Arun District Council
Arun Civic Centre
Maltravers Road
Littlehampton
West Sussex BN17 5LF
Planning & Building Control General Enquiries
Tel: (01903) 737756 Fax: (01903) 730442
Dx: 57406 Littlehampton
Minicom: 01903 732765
e-mail: planning@arun.gov.uk
website: www.arun.gov.uk/planning

Application No: EP/14/21/HH
Site Address: 38 The Roystons East Preston BN16 2TS
Description of works: Single storey side and rear extensions and conversion of roofspace to habitable use

Thank you for your internet representation made on 8th March 2021 which has been recorded as an objection with the comments as follows:

Drawing
Proposed roof plan

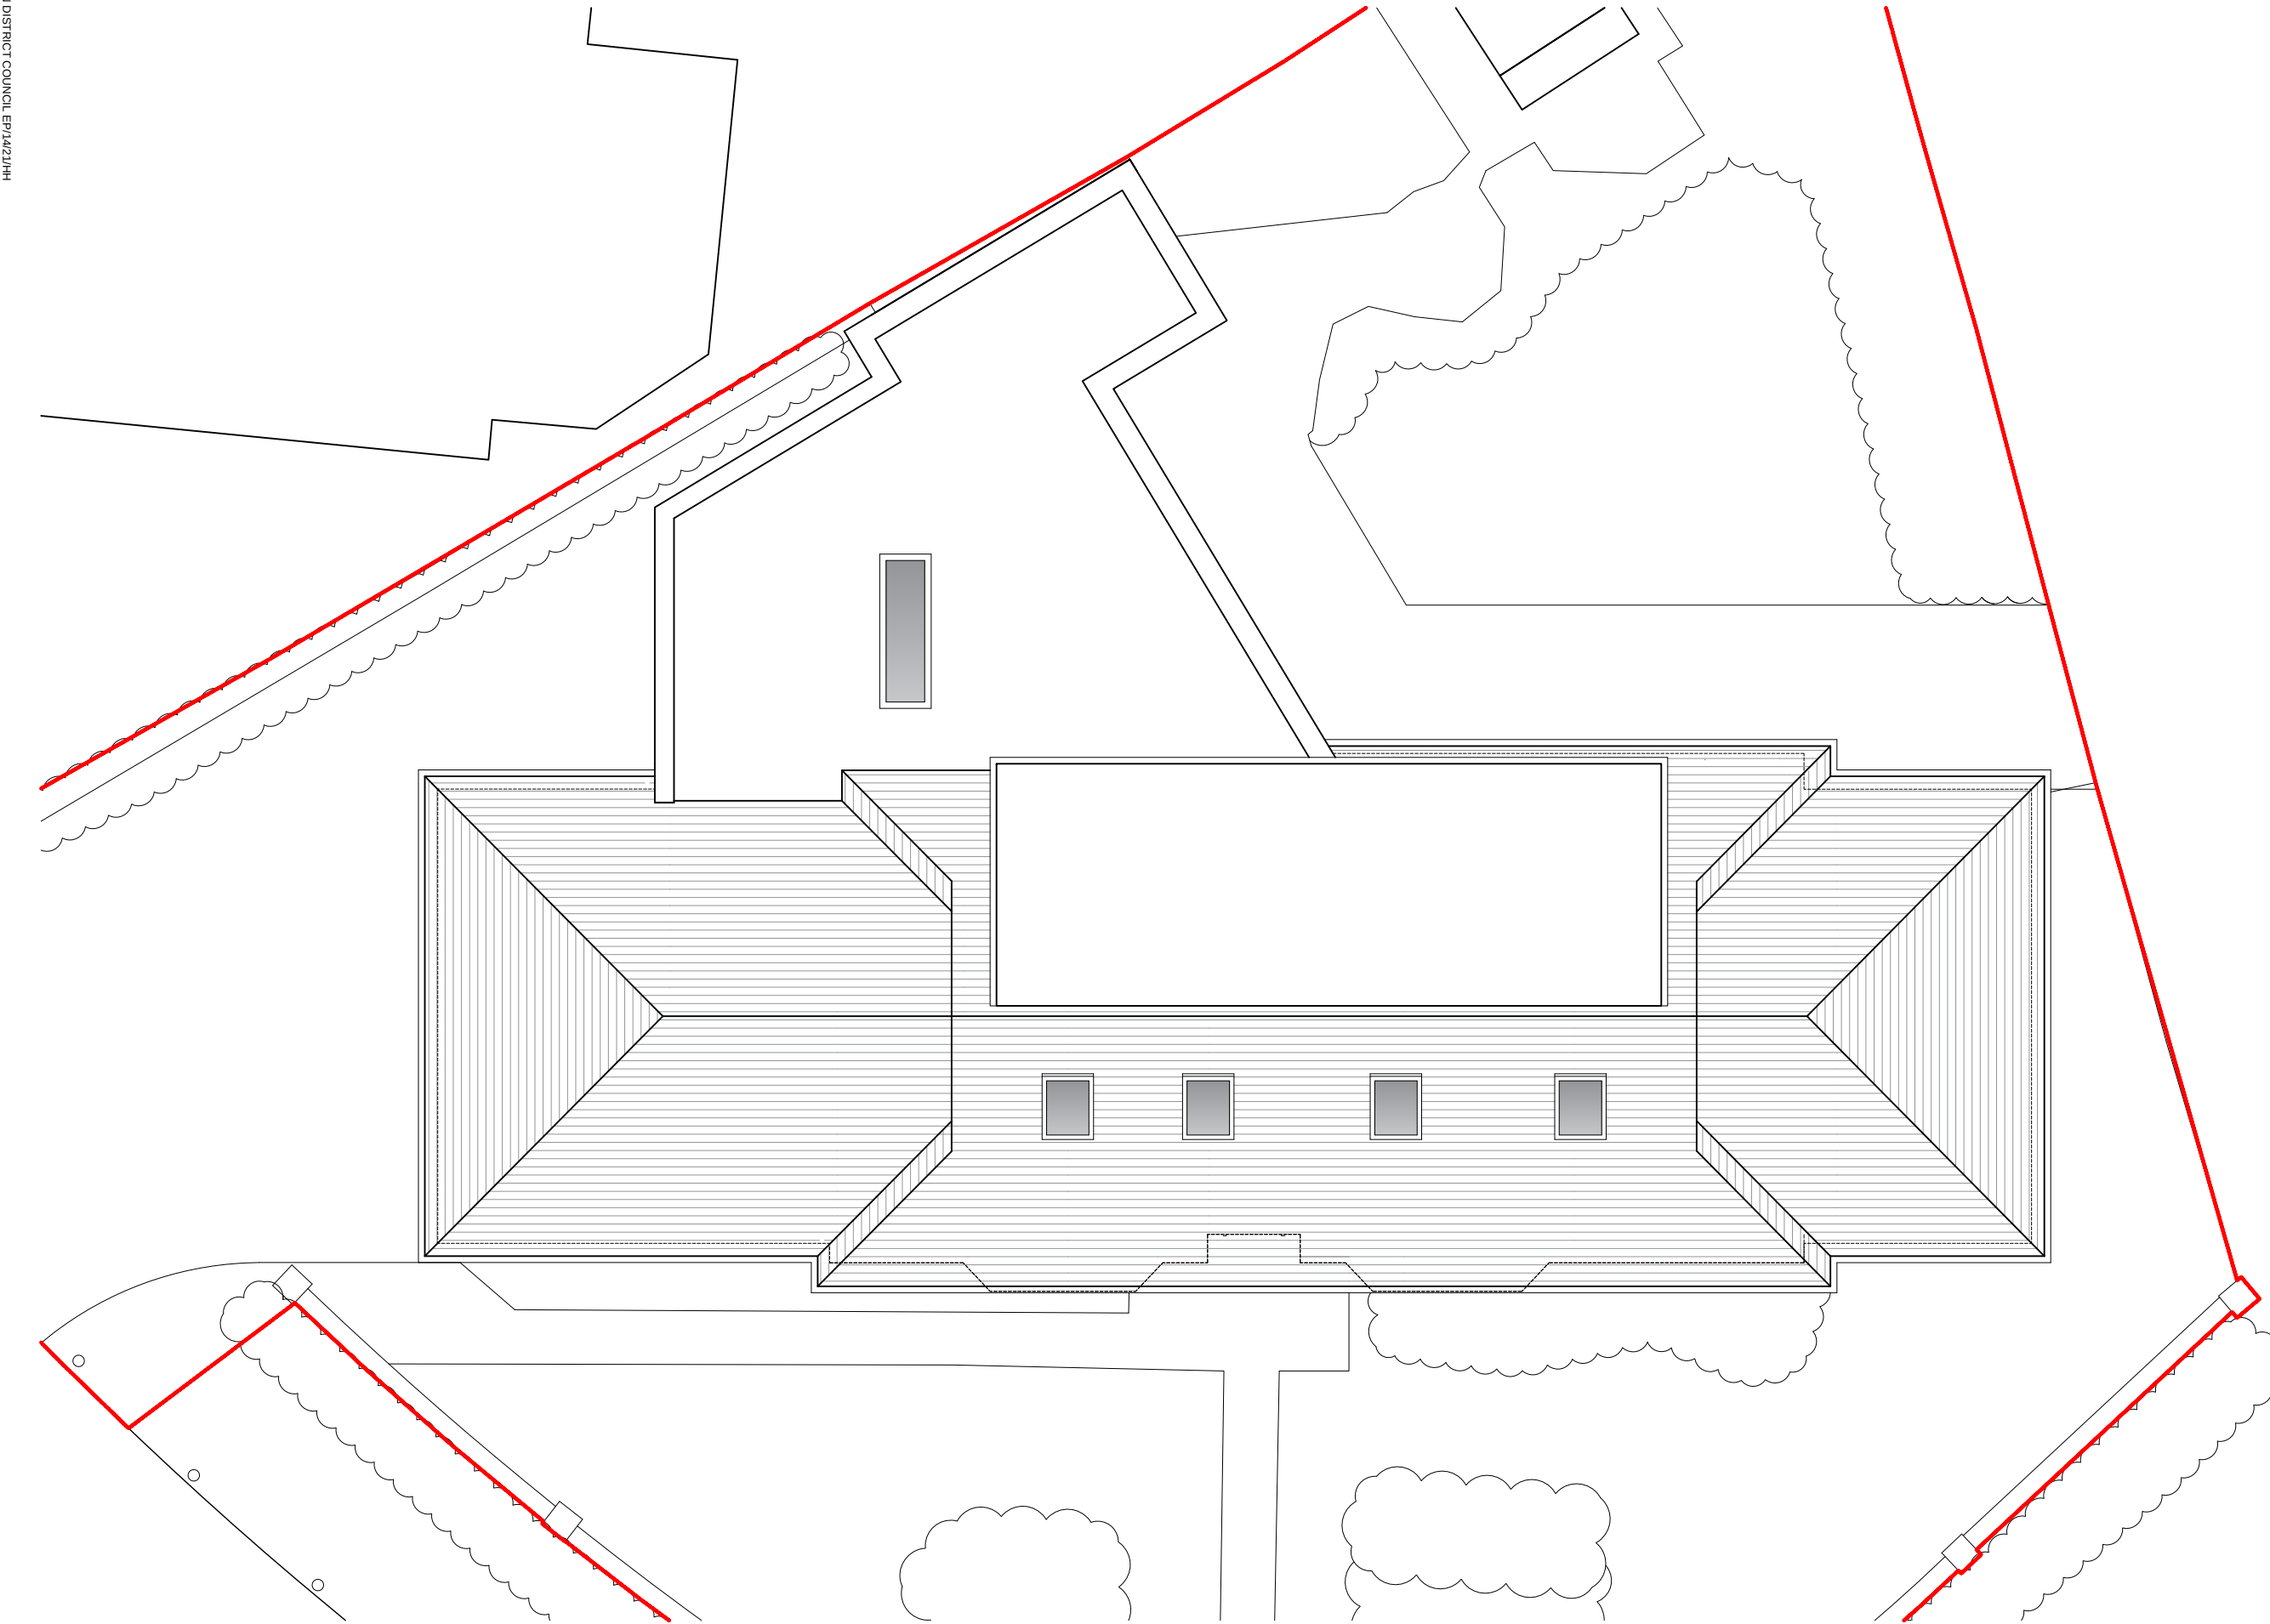
I write to submit an Objection to the submitted plans for 38 The Roystons. I support the desire to refurbish this property but my objection relates to the proposed dormer addition/extensions which will be overbearing and not suitable in its size and scale to other surrounding properties and the plot itself.
